OXFORDSHIRE COUNTY COUNCIL'S RESPONSE TO CONSULTATION ON THE FOLLOWING DEVELOPMENT PROPOSAL

Application No: 16/02482/REM

Proposal: Reserved matters to 13/00433/OUT - Siting, design, external appearance, landscaping, lap, infrastructure, points of access and associated works for 207 new dwellings

Location: Land South West Of Bicester Adjoining Oxford Road And Middleton Stoney Road Bicester

**HOUSE TYPE P PLANNING DRAWING
4 BED DETACHED
PROPOSED PLANS
1:100 @ A3
HTPD_C4006 05**

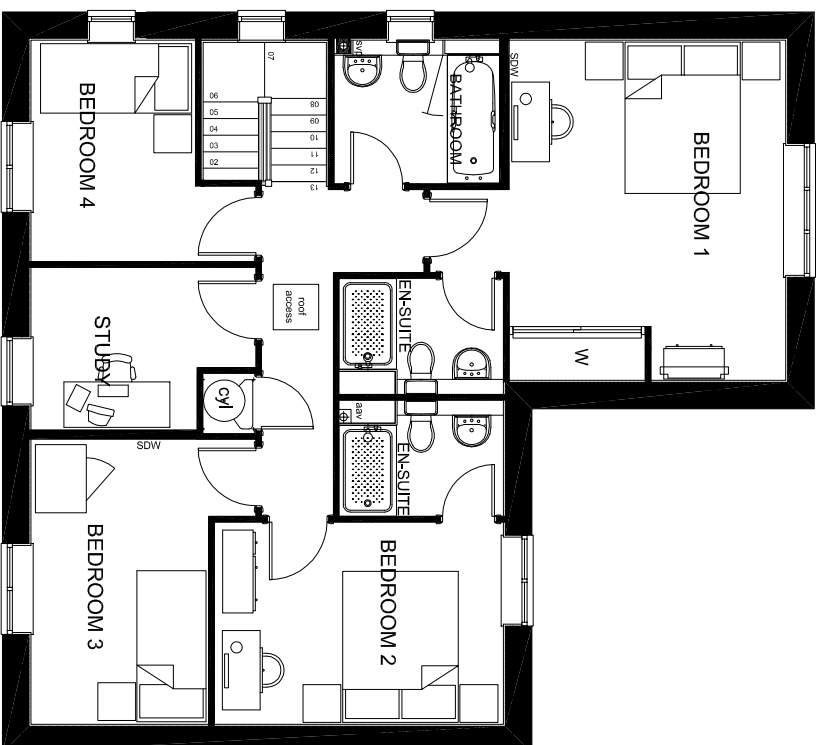
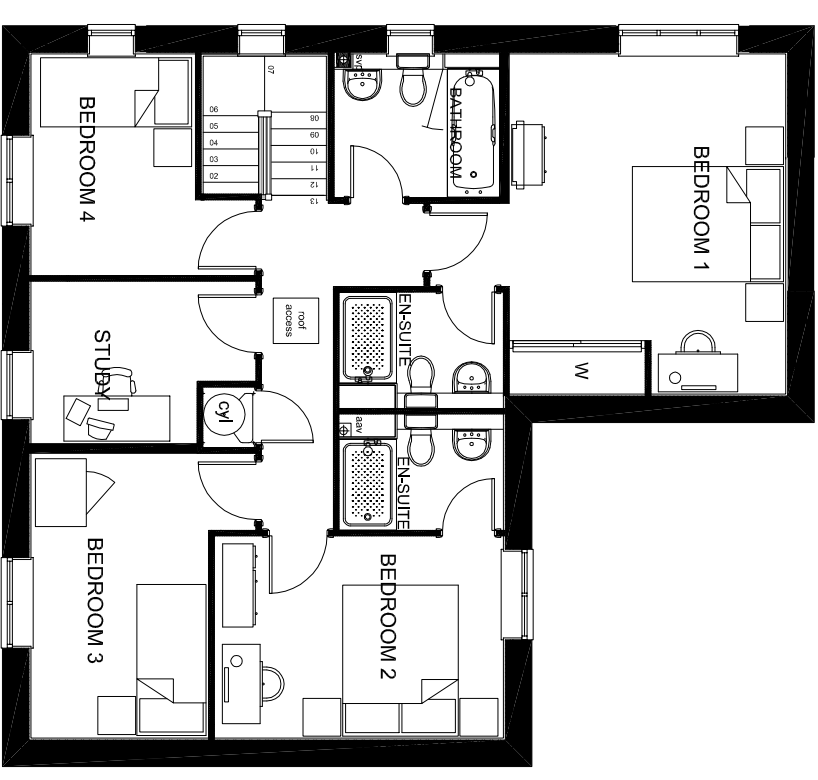
- Analysis shows the refuse vehicle tracking over what is a private area outside plot 41. On the exit the same turning head, it also shown to sweep over a visitor parking bay fronting plot 41.

DRAWING TITLE: S2 APARTMENTS - ELEVATIONS
 MARKER A

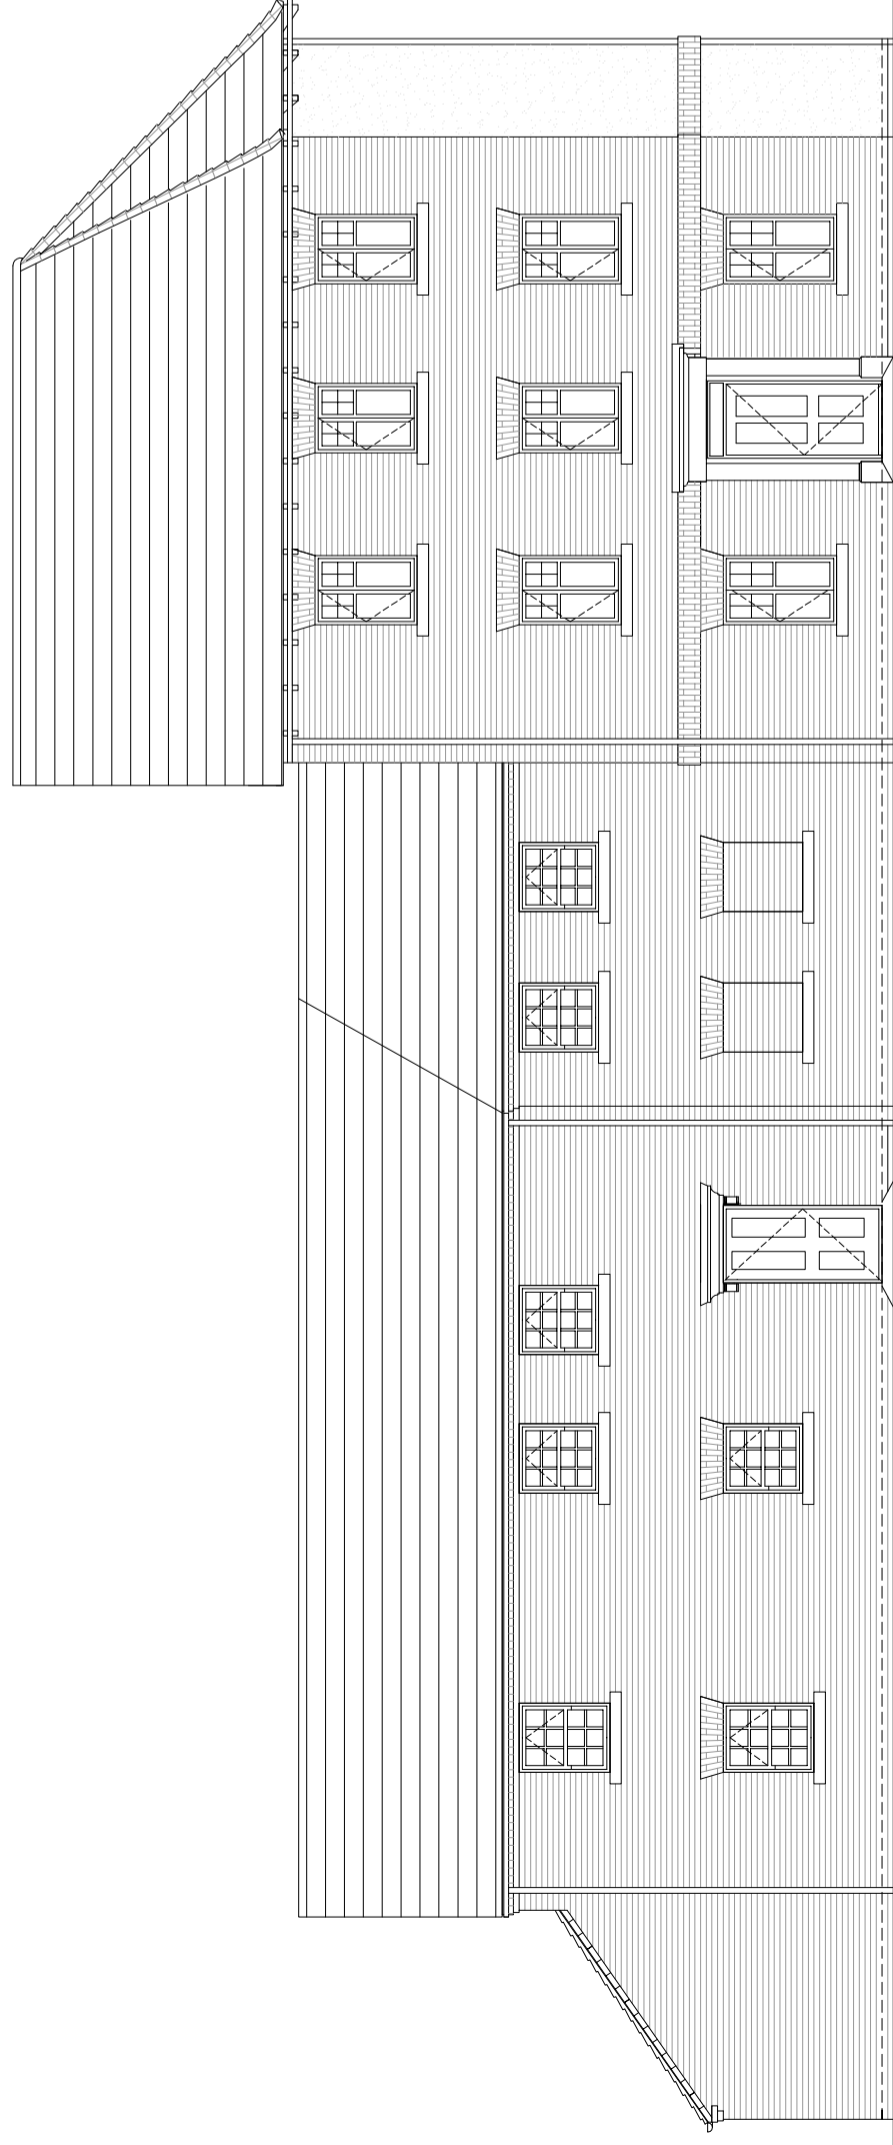
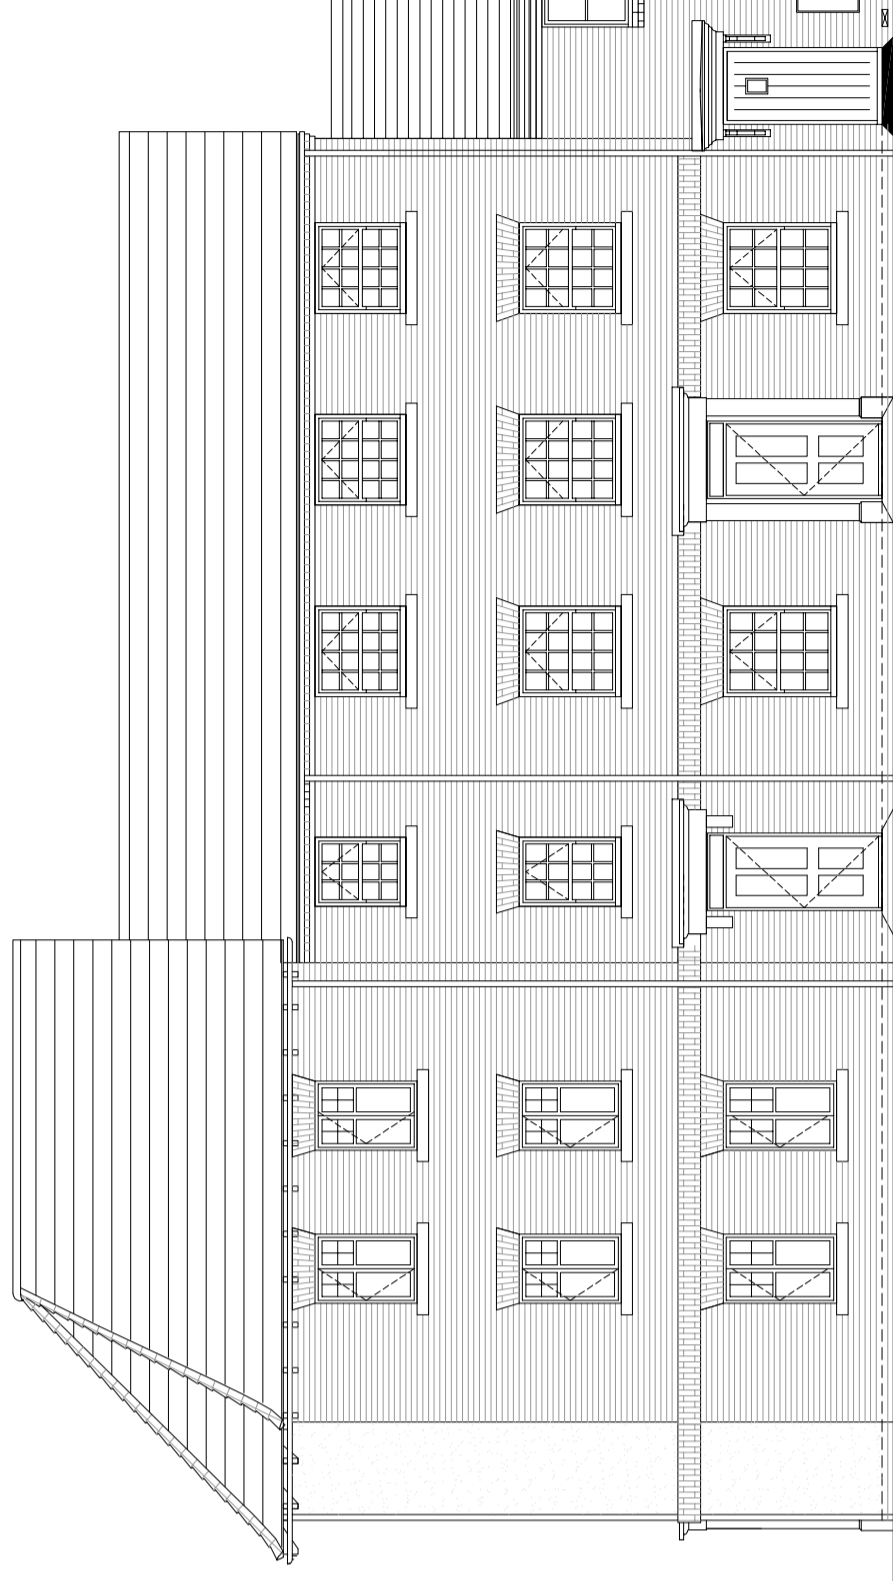
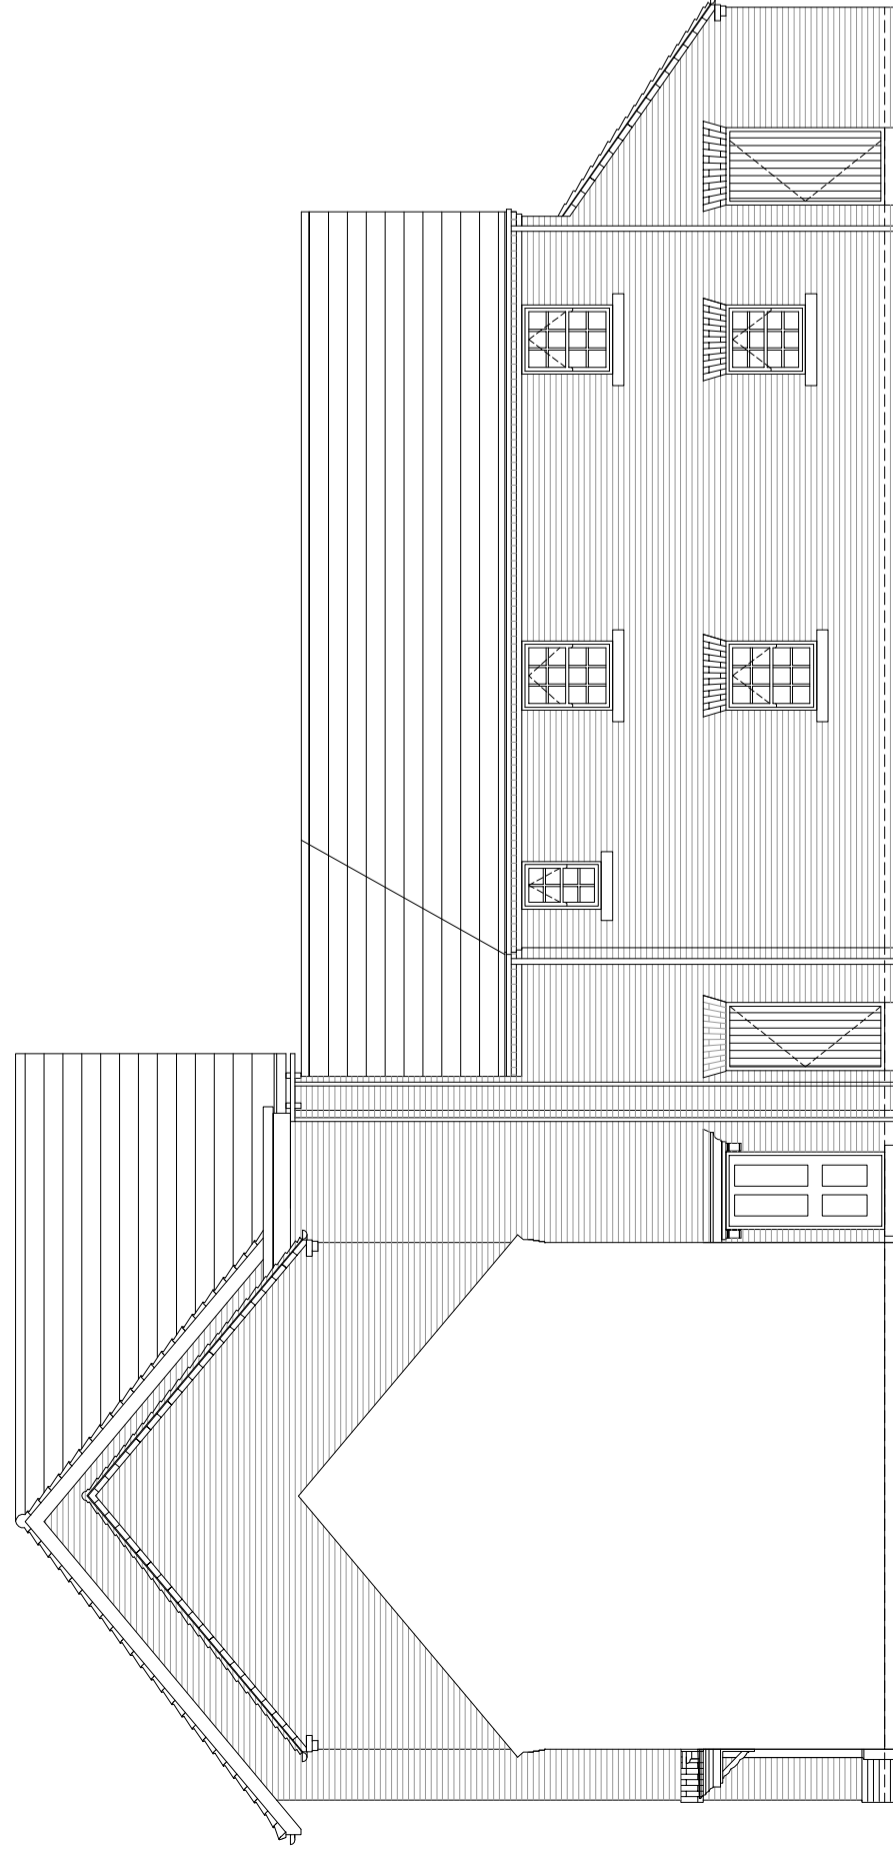
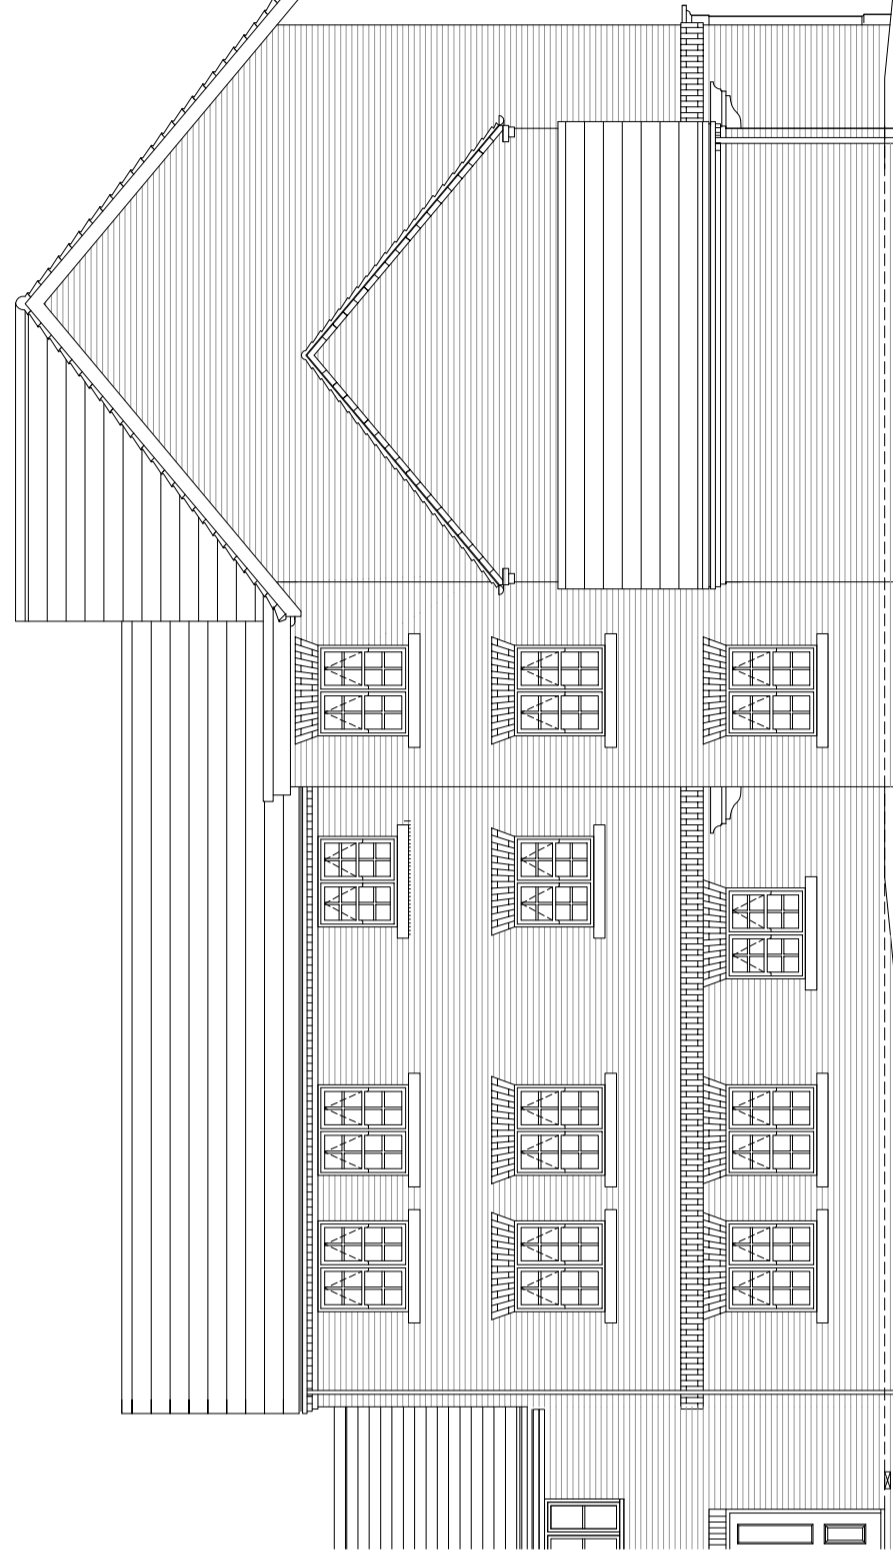
Access to the cycle storage for apartments 1-8 is poor. Cyclists generally require a width of 1100mm to push their bicycles by holding onto them. The layout plan shown by drawing number **HTPD_S7_01** entitled "*S2 Apartments – Plans Marker A*" suggests the dimensions to the cycle storage entrance are 0.8metres. This needs to be adjusted to a minimum of 1.1metres ensure that adequate access is provided for both cyclist and cycles to use the facilities. It is also unclear as to the detail design of the facilities proposed here. These details (preferably of the Sheffield type) shall be required to be submitted prior to the occupation of the dwellings.

Dedicated bin storage for the S7 apartments is shown on drawings referenced by **HTPD_S7_01**. It is noticed from the drawings that the entrance to this storage area is approximately 1m wide, which the applicant must submit the details including the dimensions of the bins proposed. It is also worth mentioning that a hardstanding route/strip clear of obstacles shall be expected between these large bin storage areas to either the nearest bin collection points (bcp) or within reach of the nearest refuse vehicle. This route should preferably be away from any parked vehicles.
